Application number: 2023/93539	
What is the application for?:	Outline application, including the considerations of access appearance, layout,
Address of the site or building:	Land adj, Ledgard Bridge Mill, Back Station Road, Mirfield, WF14 8NZ
Postcode:

Type of comment: An objection	
Do you wish your comments to be published on the website anonymously?	<input checked="" type="checkbox"/> Yes
<p>The proposed flood evacuation walkway is completely and utterly unsuitable, dangerous and represents significant risks to safety and security. Residents will still need to get through flood water to reach the walkway as the flood water breaches the river and then flows across the carpark at considerable speed towards the existing narrow exit onto Back Station Road. I have personally experienced the force of the current and know that this will be extremely dangerous and impossible for many of the residents when trying to get to the start of the walkway.</p> <p>The plans state that residents will be required to 'step on parapet and swing legs over the wall to effect escape'. This demonstrates the total and complete contempt the applicant has for the residents of the existing building. Residen

Flood Warning Procedure – Safe Exit Route overlaid on JBA 100yr+CC23% flood map

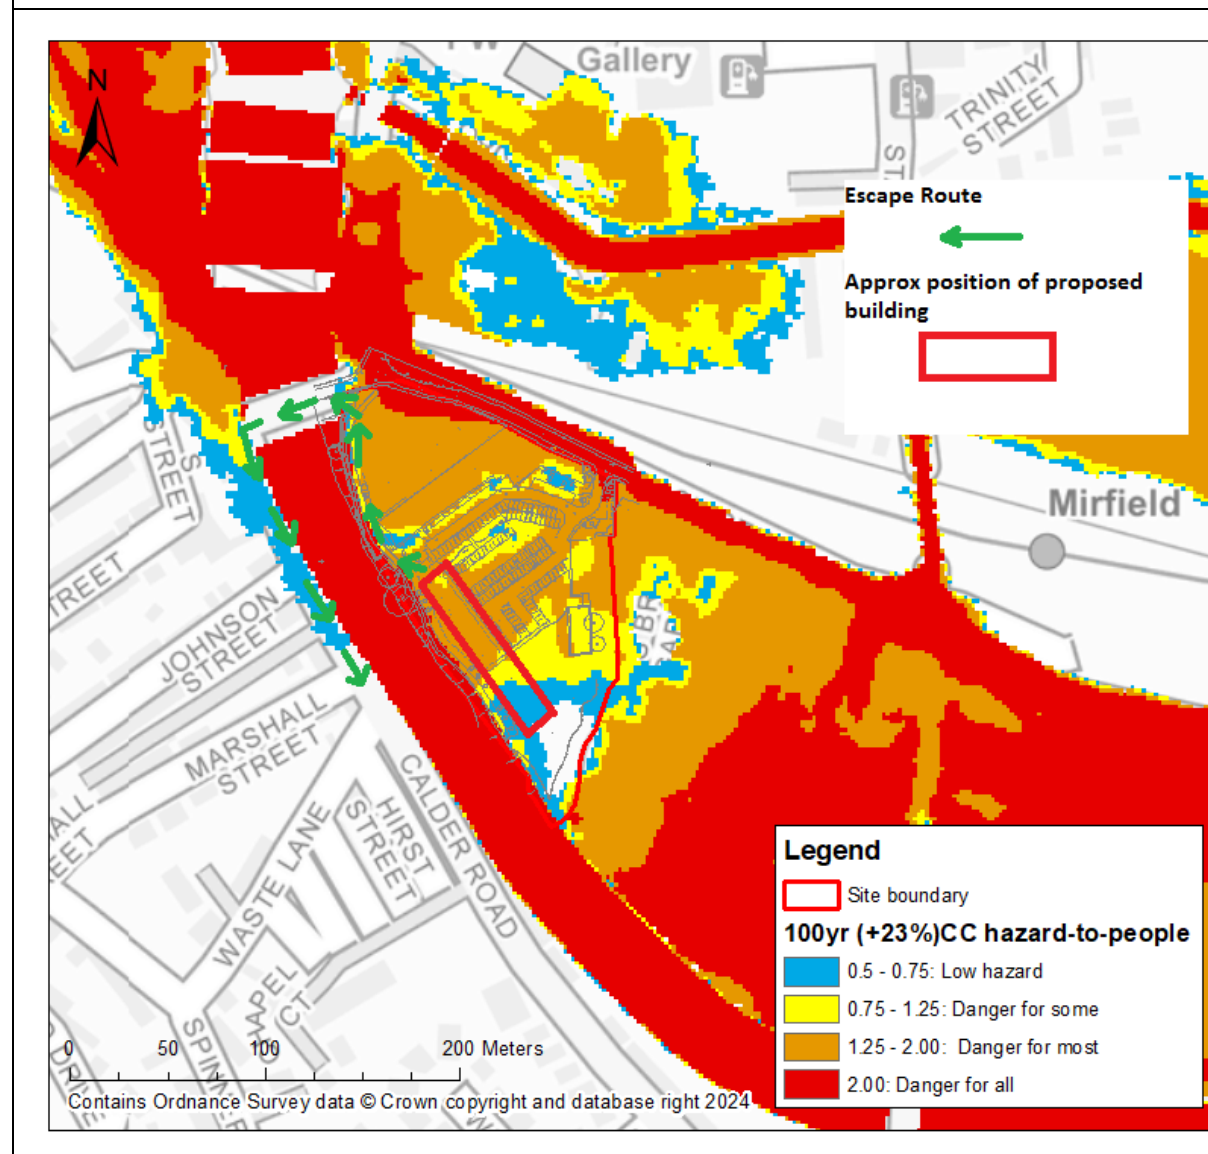
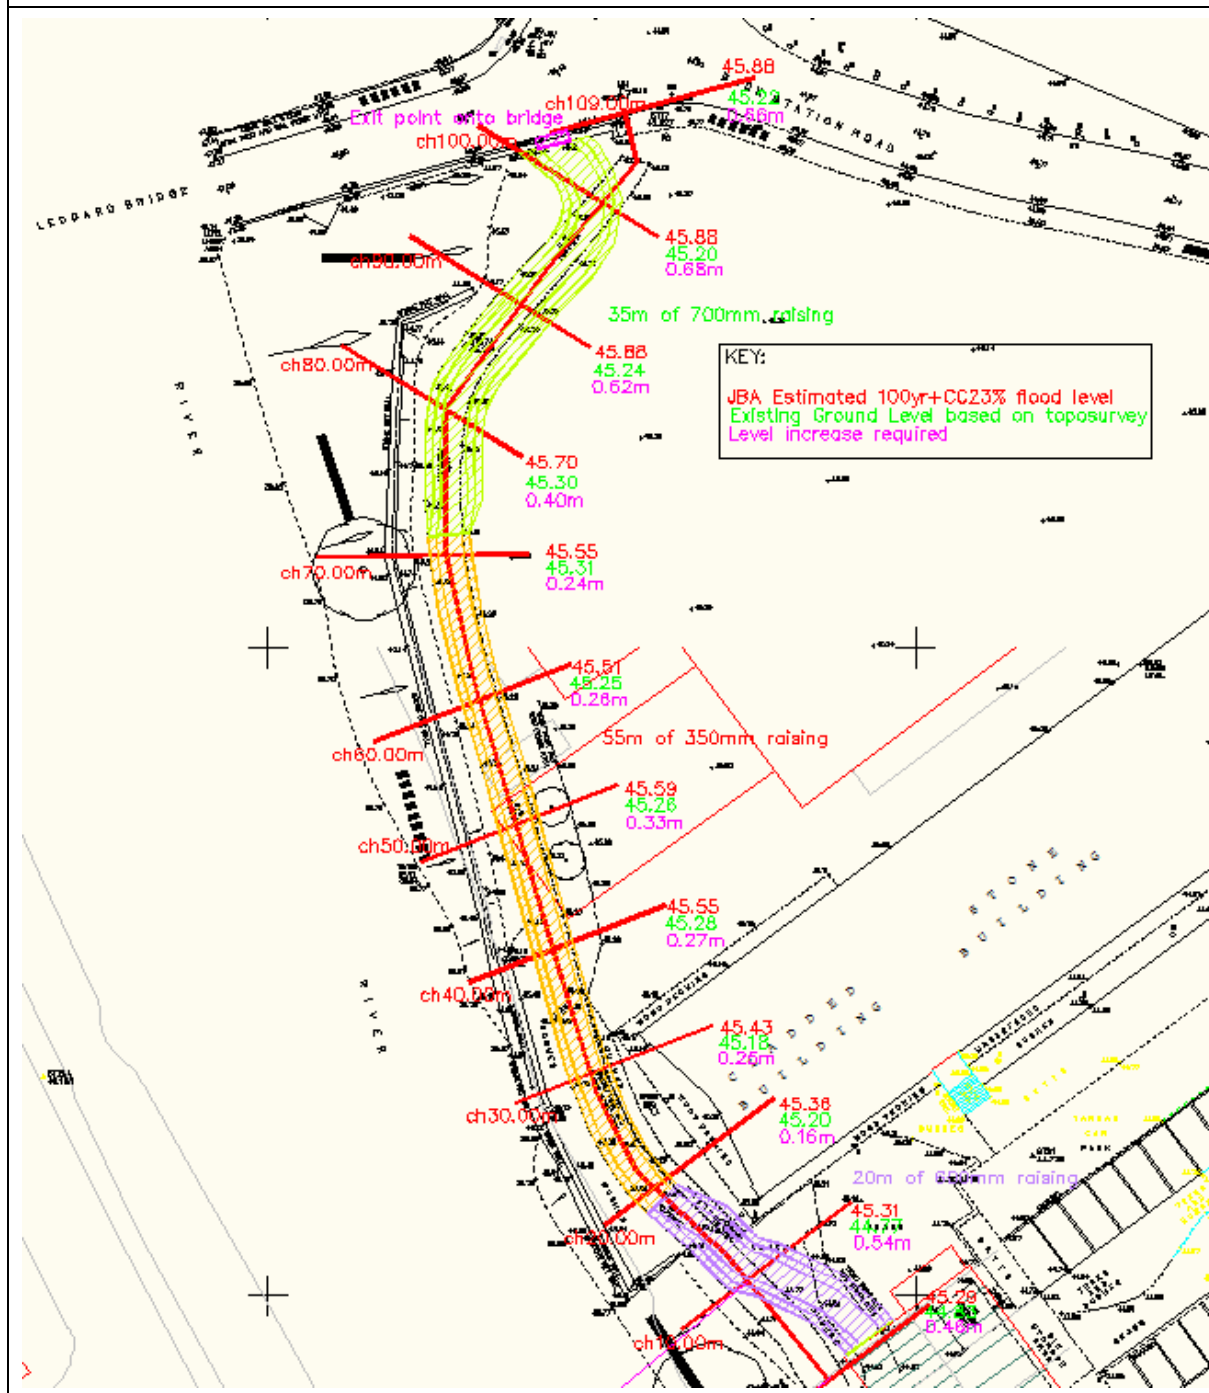
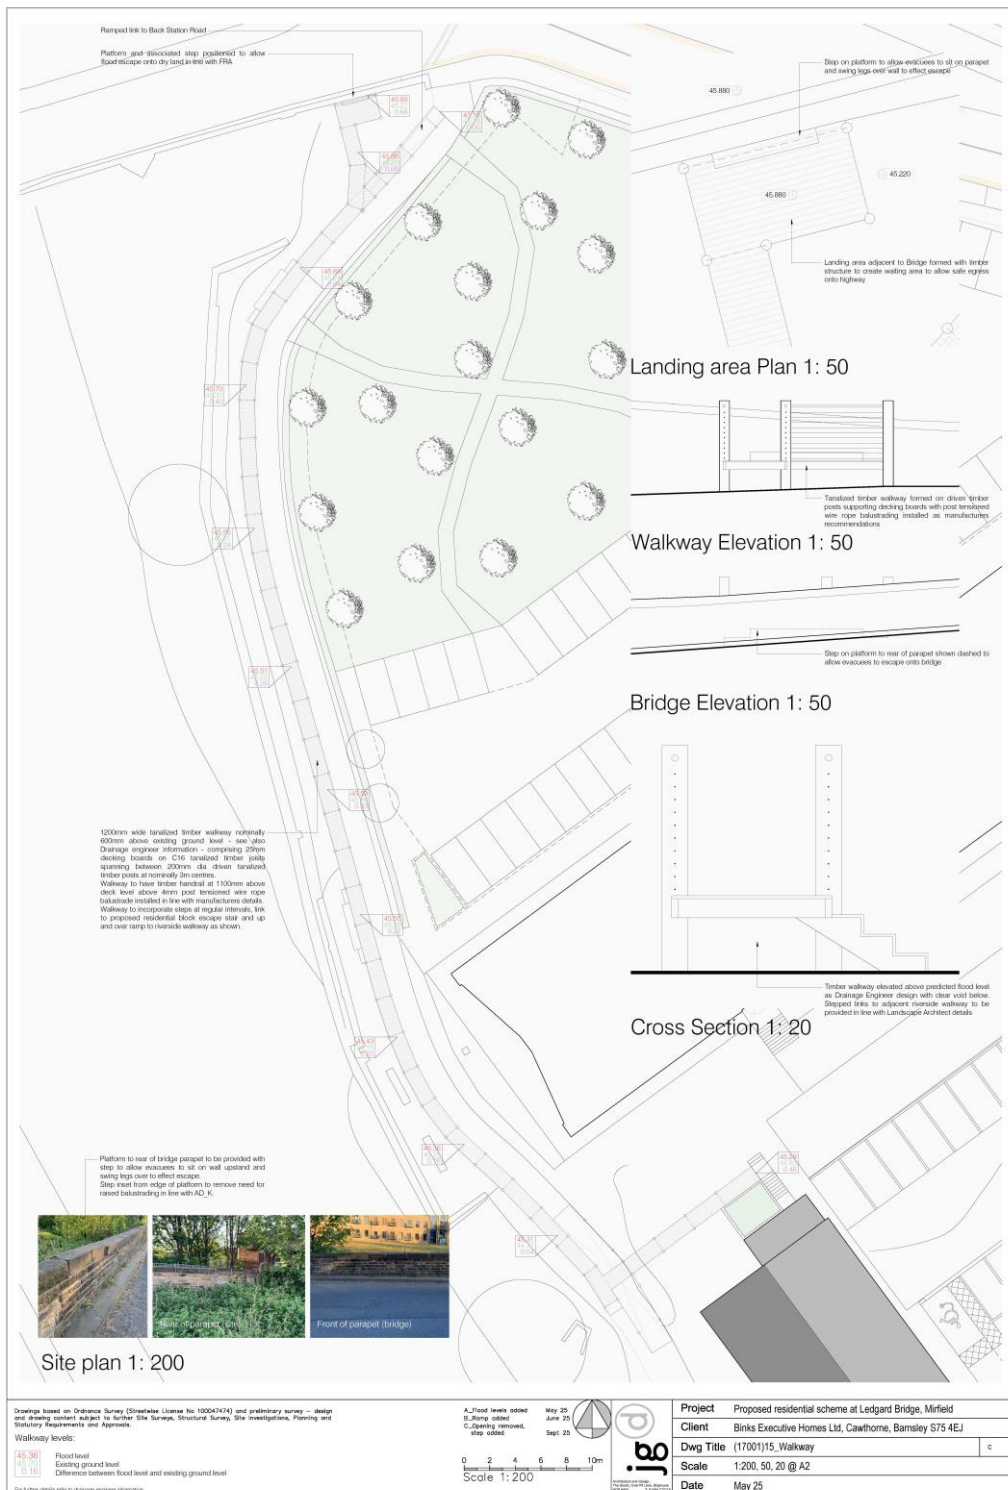
at night by gangs of young people. The proposed walkway is highly likely to encourage access and trespassing by non-residents and represents a significant security risk to residents and our vehicles. It will also become a shortcut for people who want to get from Lower Hopton to the railway station and shops, again encouraging trespassing on private land.
